RE: Indaver Ringaskiddy_ ACP planning application 318802.
Your ref: Land area measurement included in Application.

Dear Joe,
Attached please find Map 1, Map 2, Map 3, Map 4 and Map 5.
Plot on A3 sheets for clarity.

**Map 2\_PRAI background**  
 Scale 1:2000 on A3 sheet  
 Prepared by Con Sheehan, Land surveyor FCSI  
 on 5th November 2025

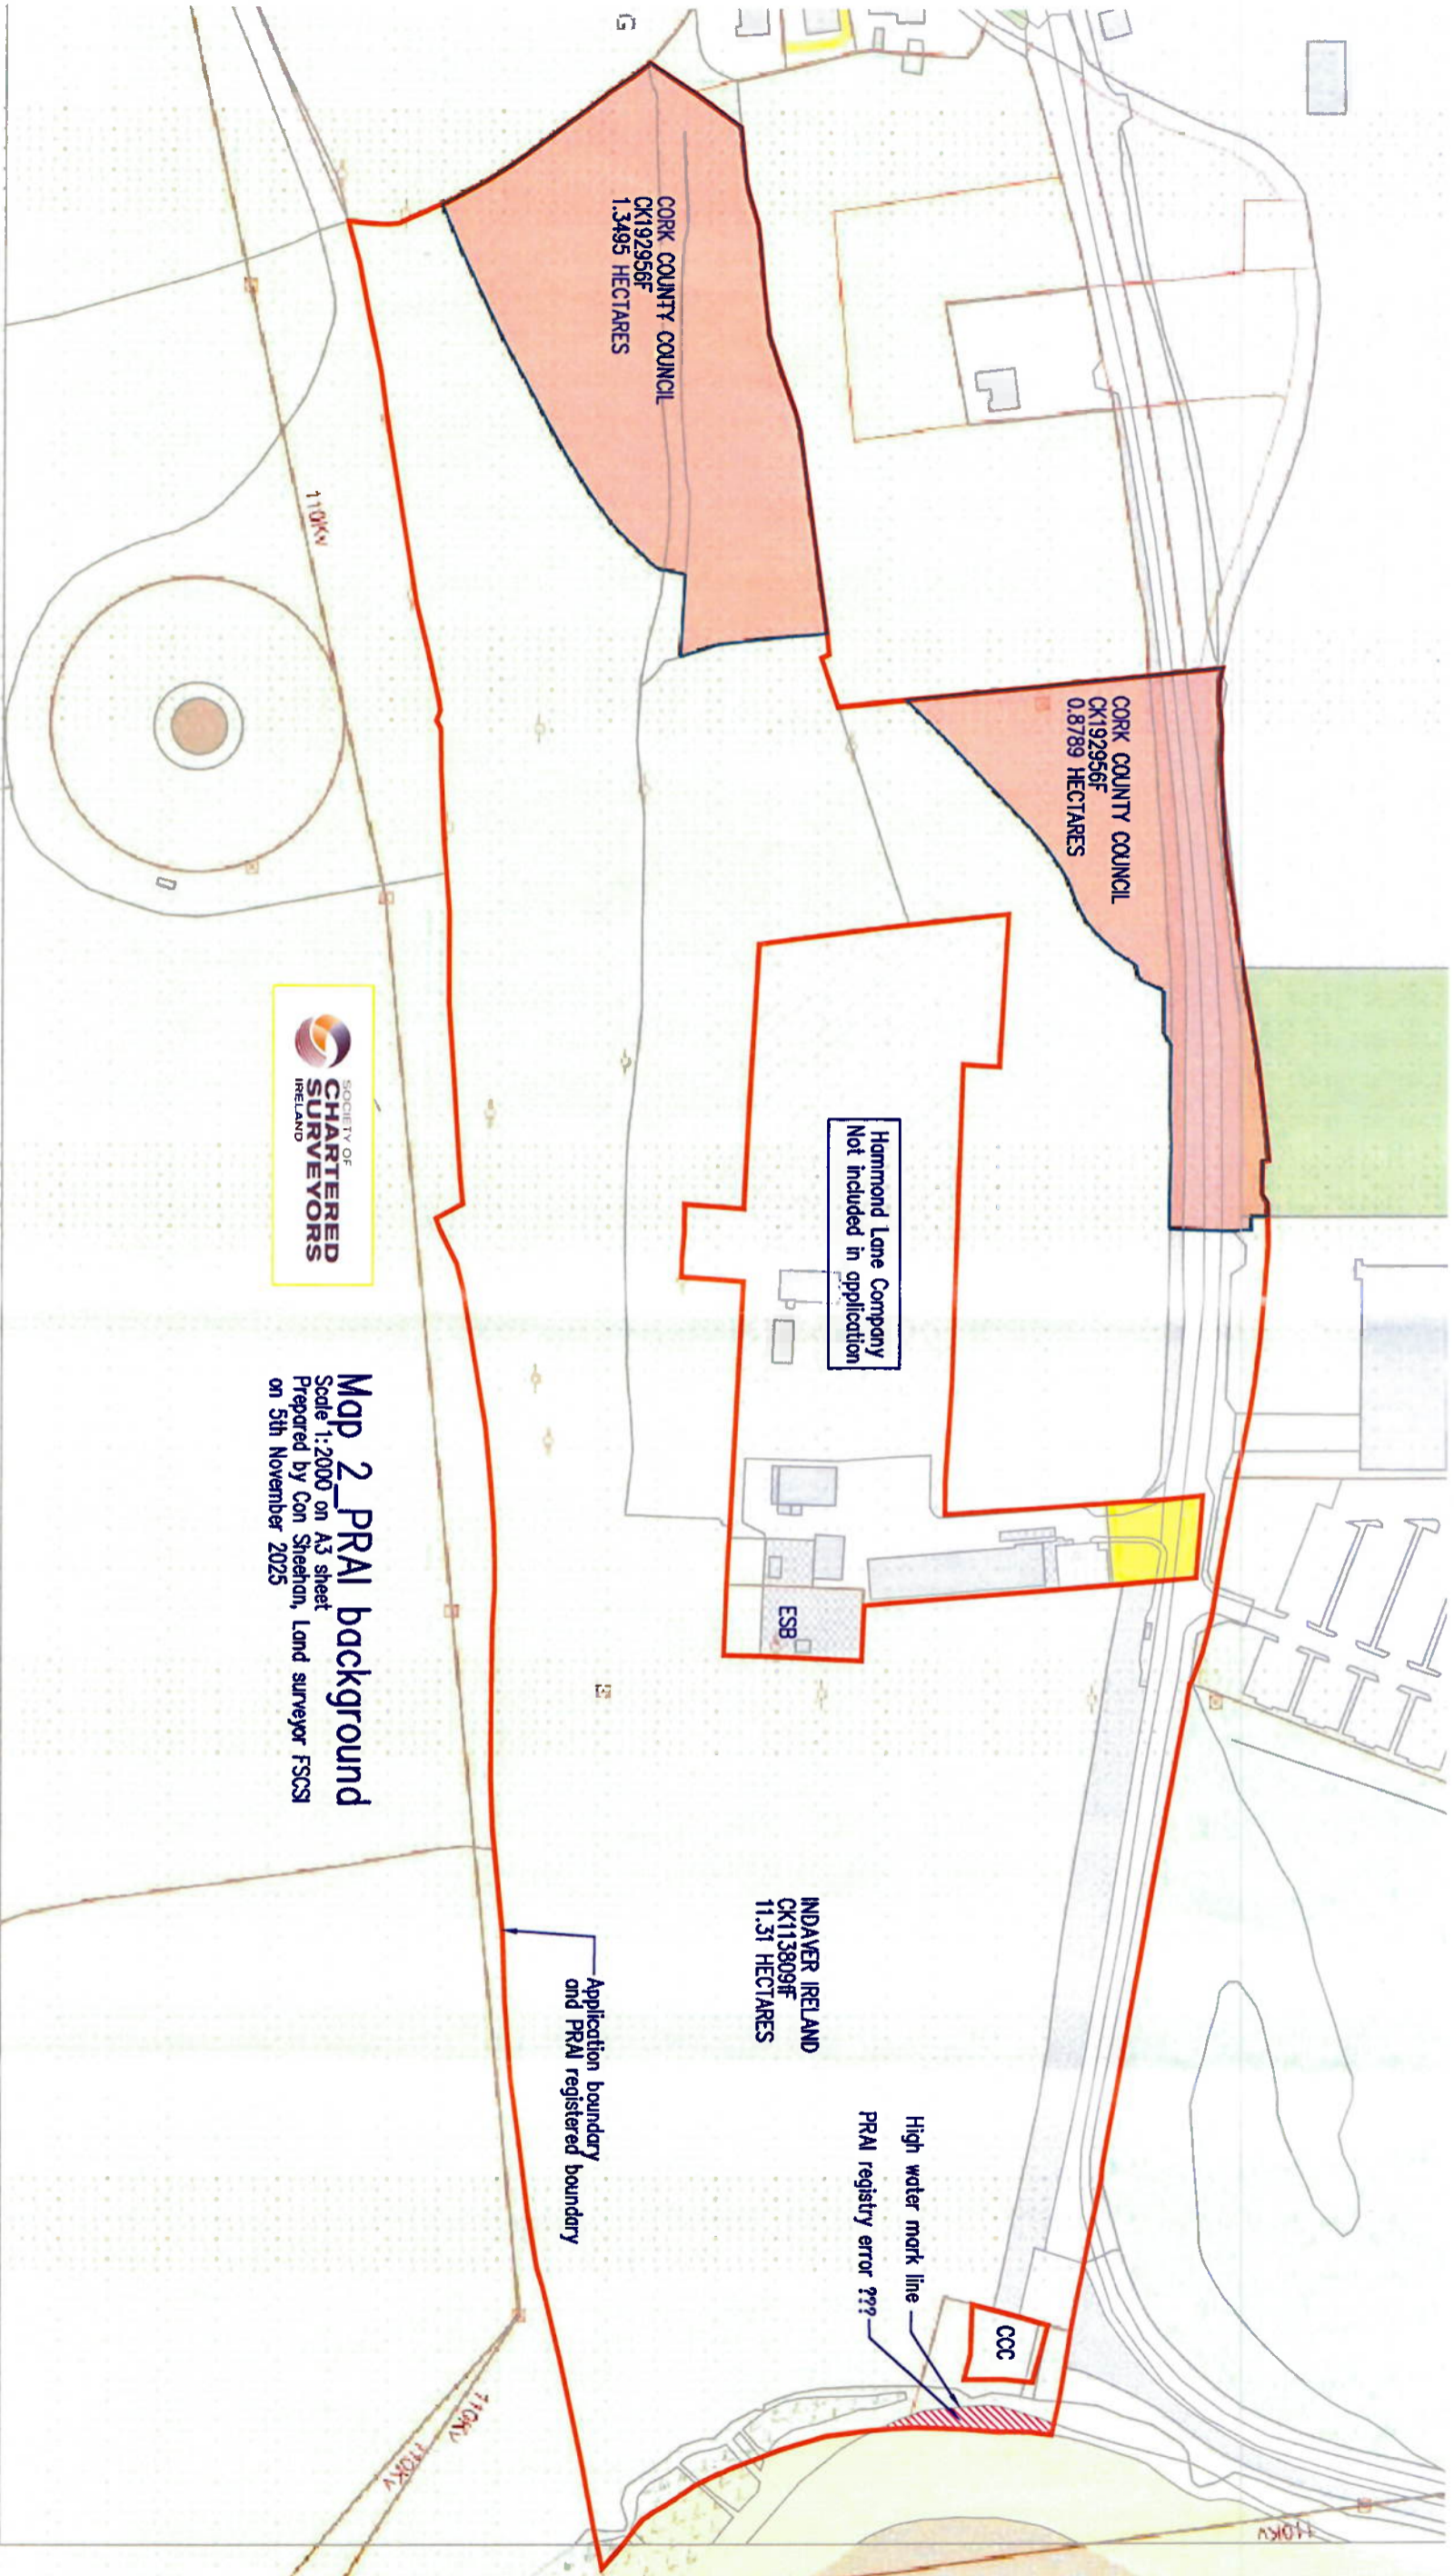
Map 2 is a download of Cork County Council folio CK192956F from PRAI with some notes added.

**Map 3 Landscape plan (FIG 4.7)**  
 Scale 1:2000 on A3 sheet  
 Prepared by Con Sheehan, Land surveyor FCSI  
 on 5th November 2025

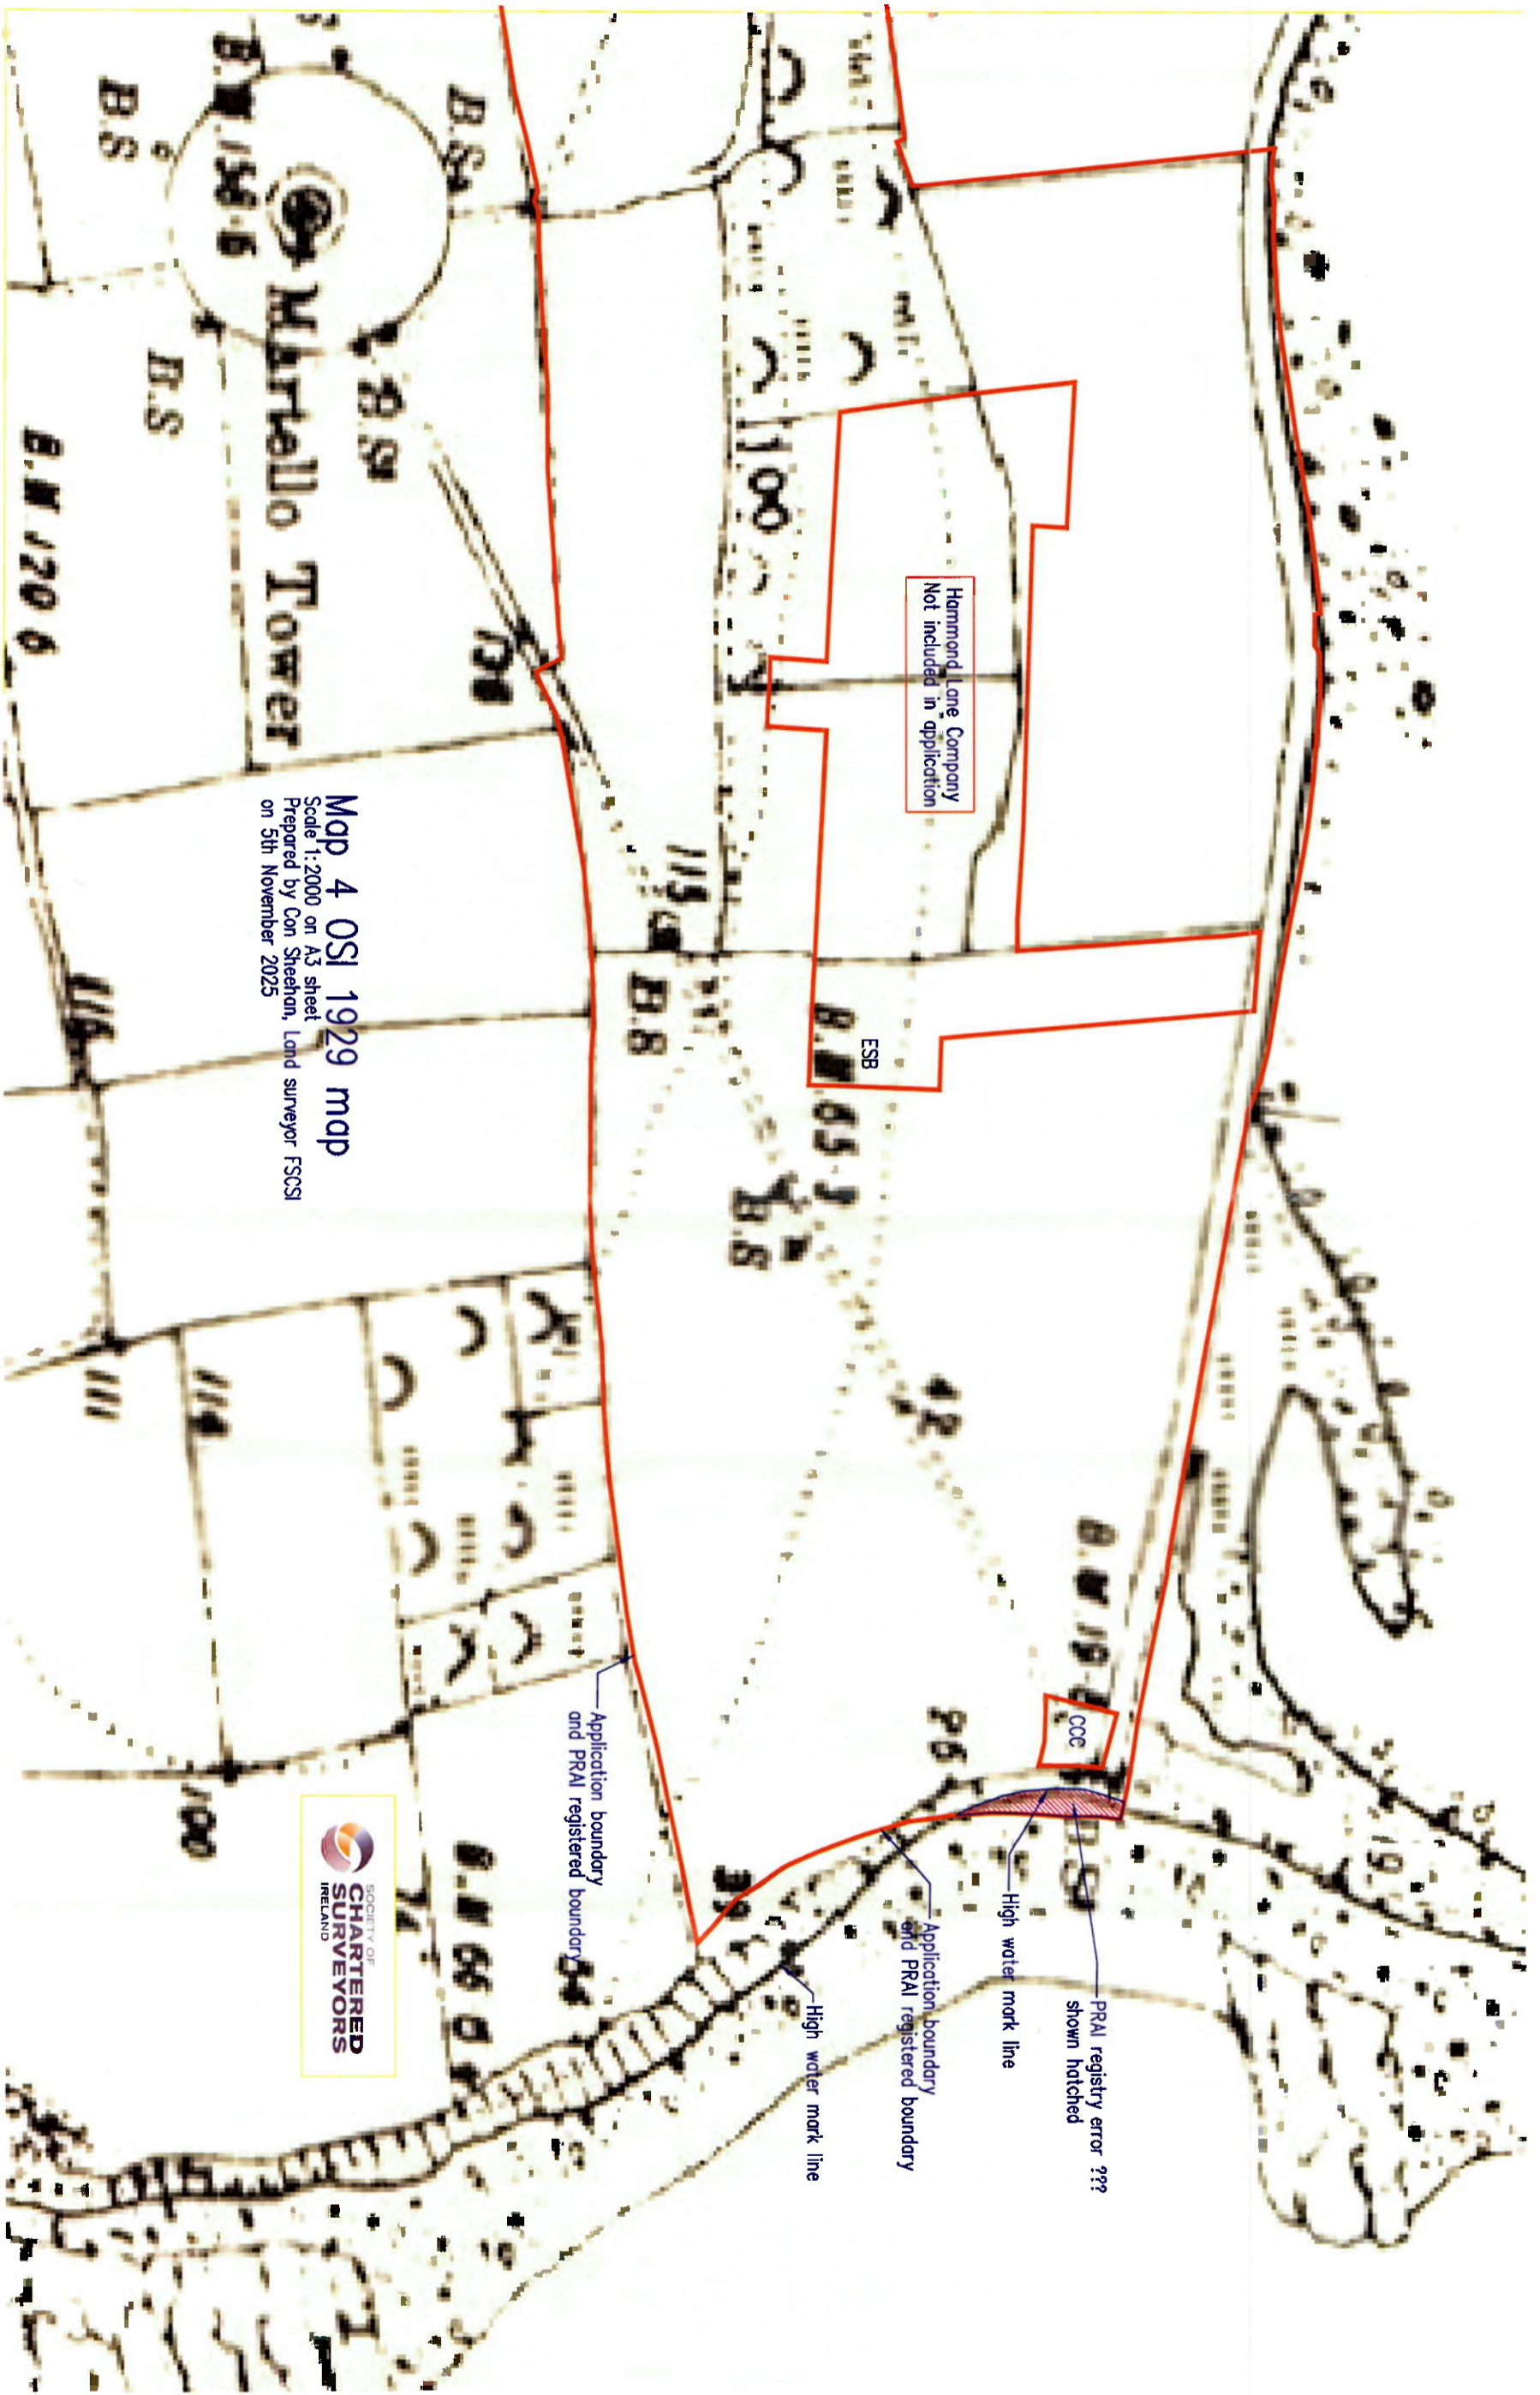
Map 3 has the landscape Vol. 3 figure 4.7 as a background. This shows a possible error in the PRAI registered title map as it does not match the high water mark from older mapping Ordnance survey mapping. It also shows the planting plan near the West boundary being on County Council Lands and on what appears to be a new roadway.

Map 4 OSI 1929 map  
Scale 1:2000 on A3 sheet  
Prepared by Con Sheehan, Land surveyor FSCSI  
on 5th November 2025

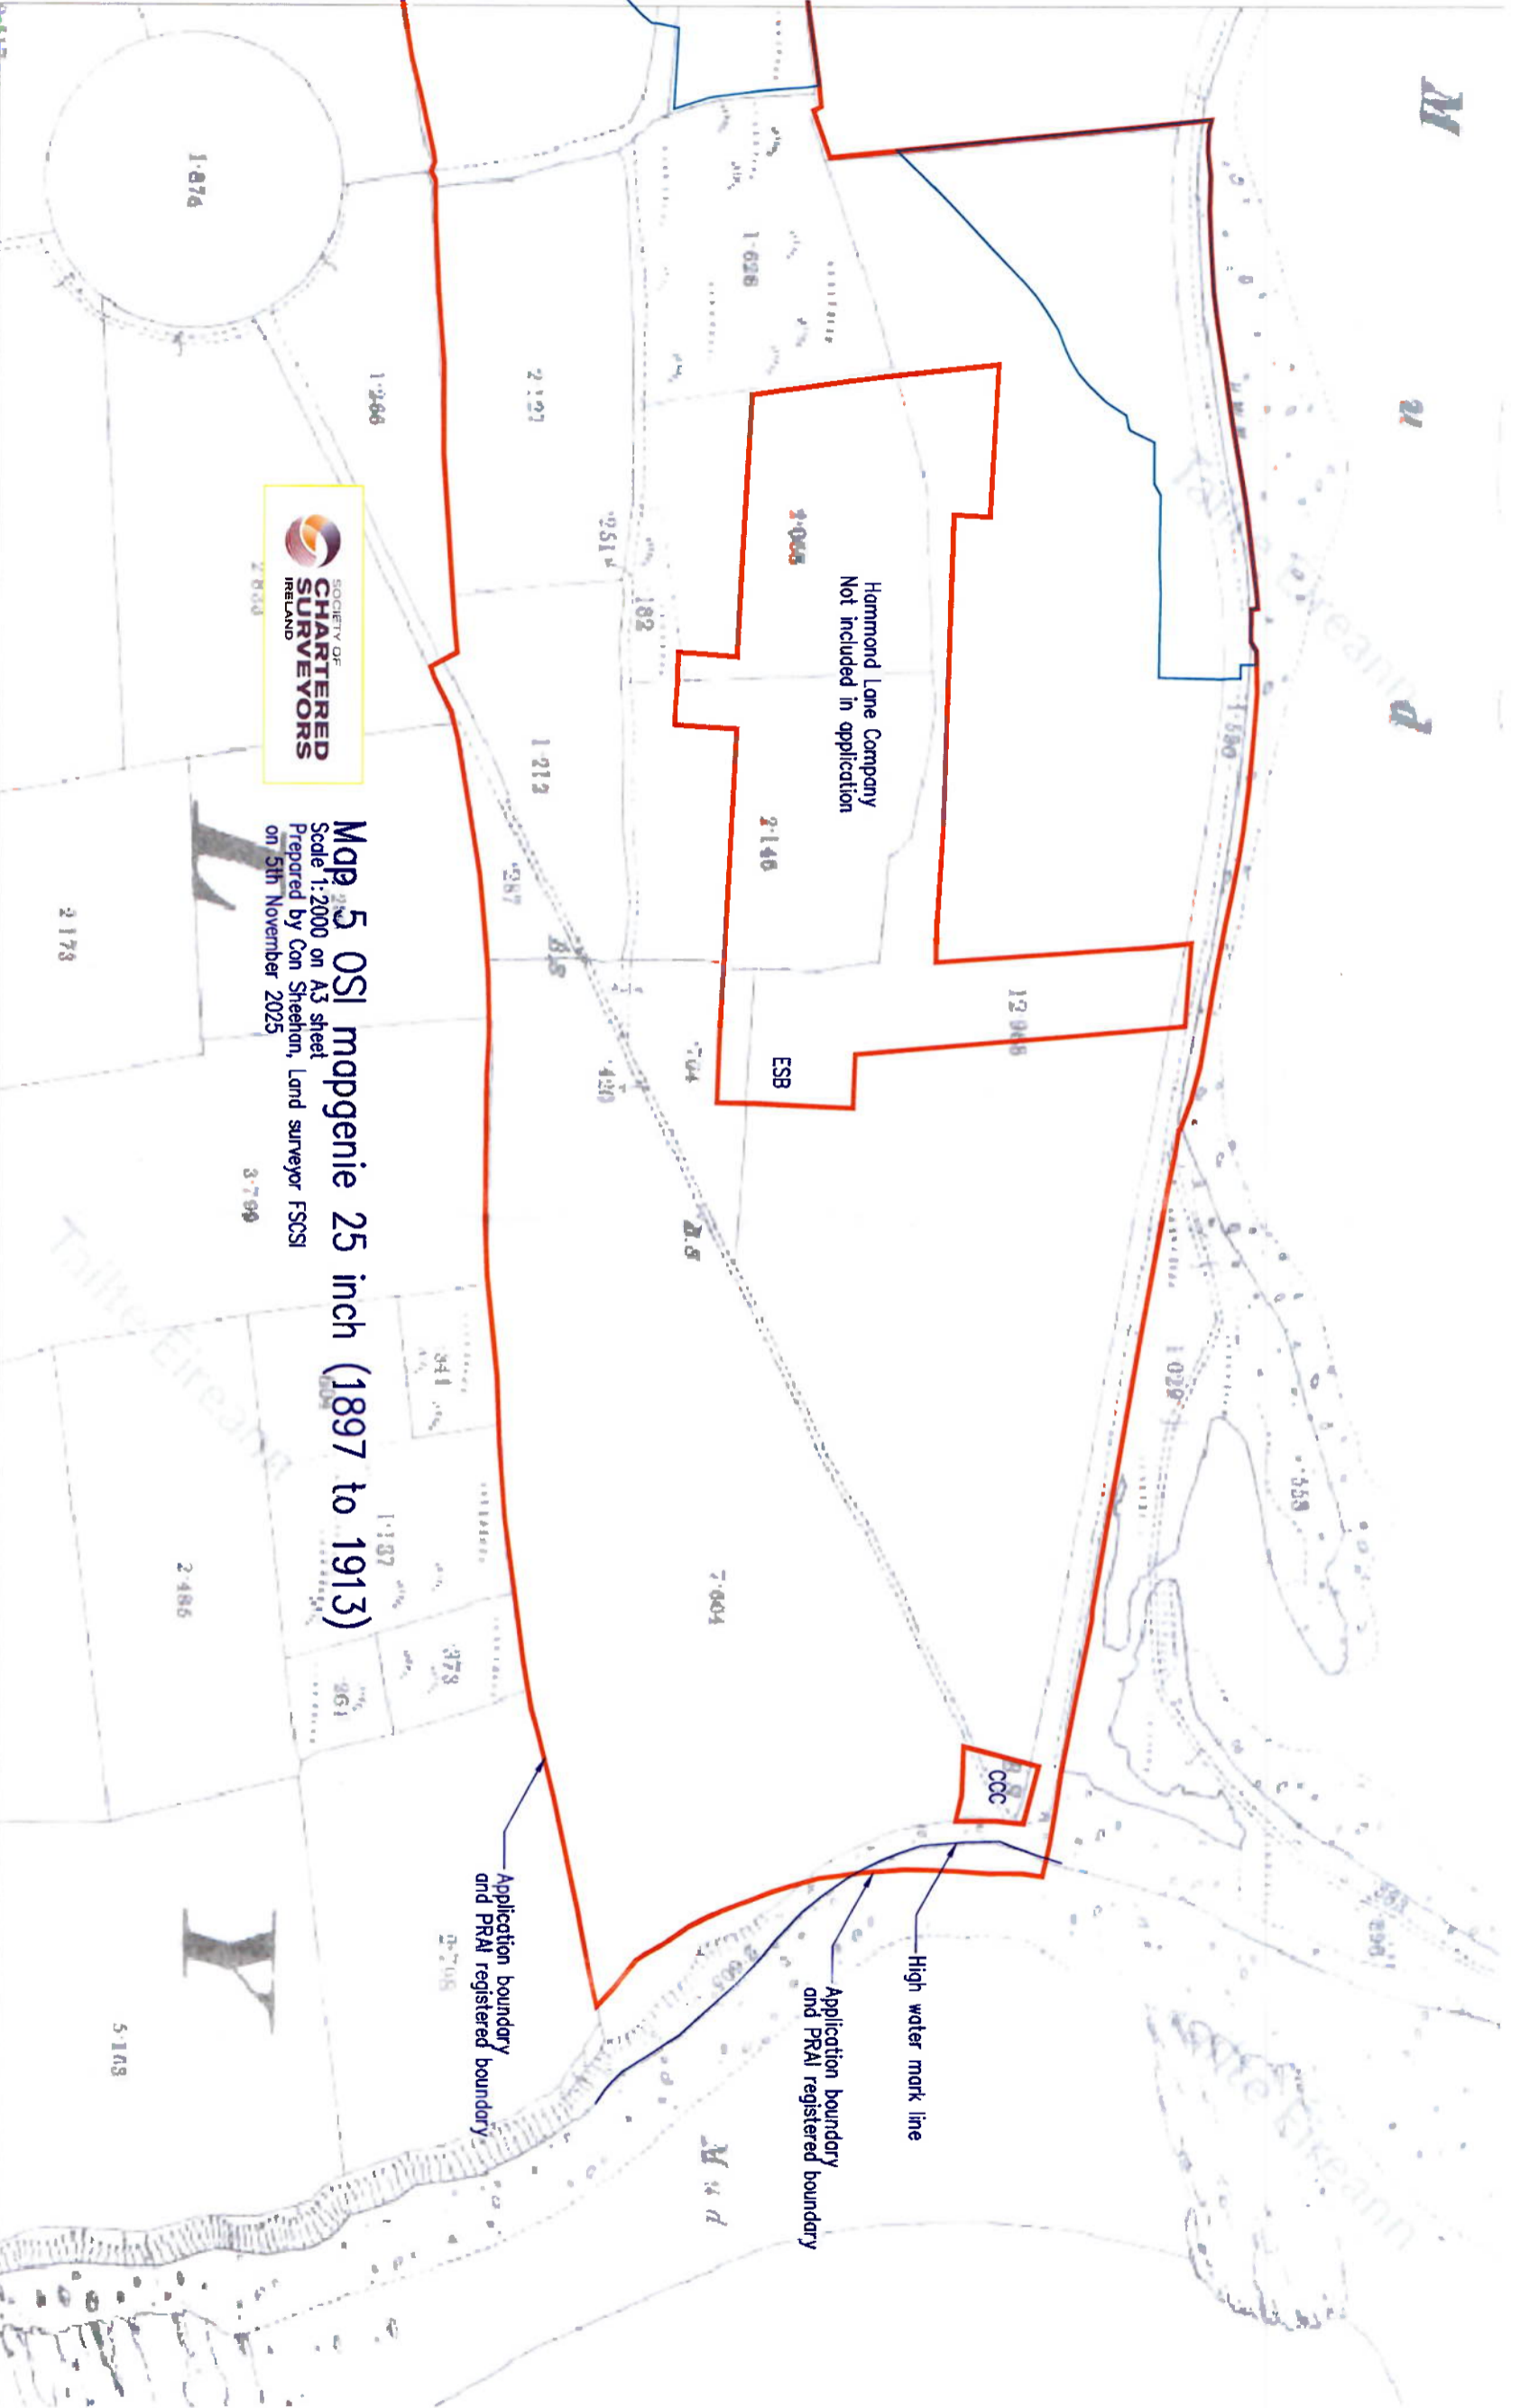
Map 4 has a background map of the Ordnance Survey of Ireland 1929 mapping. This shows the high water mark in conflict with the application boundary/folio boundary which are the same line.
